TALASAEA
CONSULTANTS, INC.

14 January 2019

REFERENCE: Review Comments for File No. CAO17-010 – Hou Critical Areas Determination 4825 E Mercer Way, Mercer Island, WA 98040; King County Tax Parcel #216200-0070

SUBJECT: Response to City of Mercer Island Comments dated 15 October 2018

**CRITICAL AREAS MITIGATION PLAN
 PROPOSED SITE PLAN, IMPACTS & MITIGATION PLAN
 HOU PROPERTY
 MERCER ISLAND, WA**

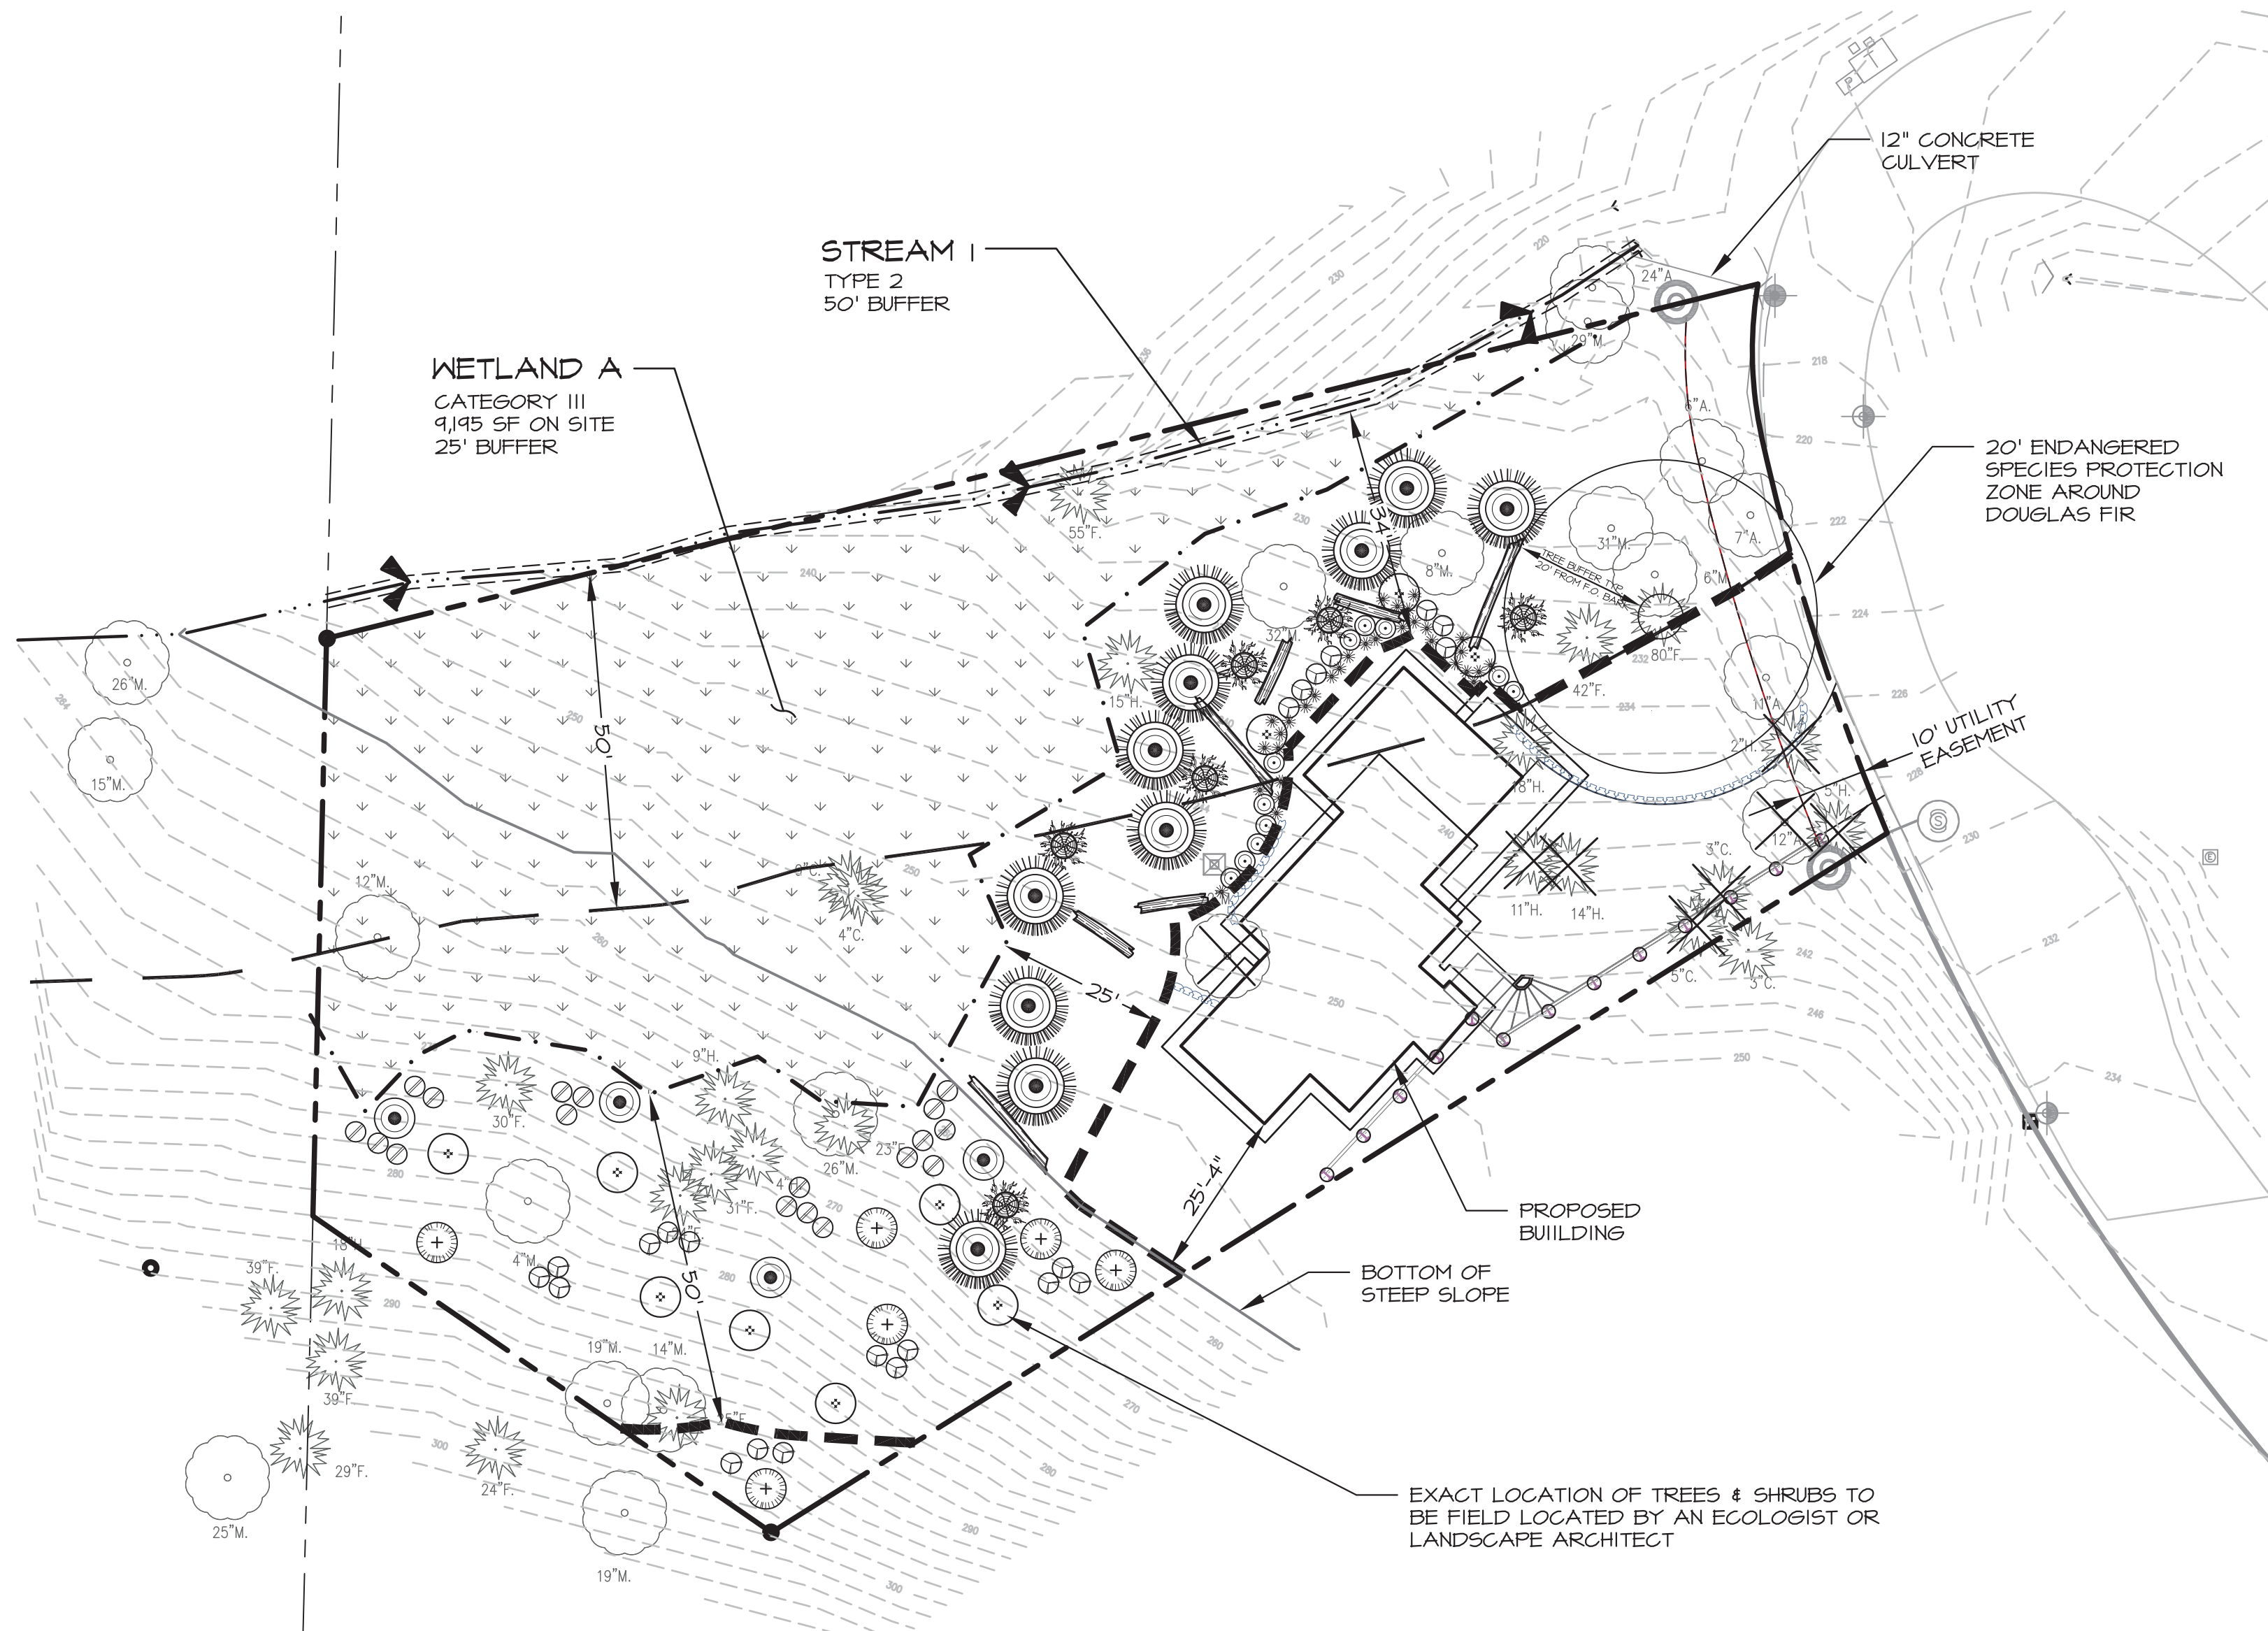
- 2. Pursuant to MICC 19.07.080(C)(2), buffer widths can only be reduced if the reduced area is adequate to protect wetland functions and the reduction will result in no net loss. Amy [sic] harm to the trees may result in net loss due to the habitat benefits currently provided by the trees. Please ask your arborist to review the proposed encroachments to the drip lines of Exceptional Trees 916 and 917 as reflected Table 1 Summary [sic] of Drip Line Encroachments and provide a report stating that the proposed encroachments will not harm the trees.**

Response: Please see the attached Arborist Report, dated 11 January 2019, that should address the concerns outlined above.
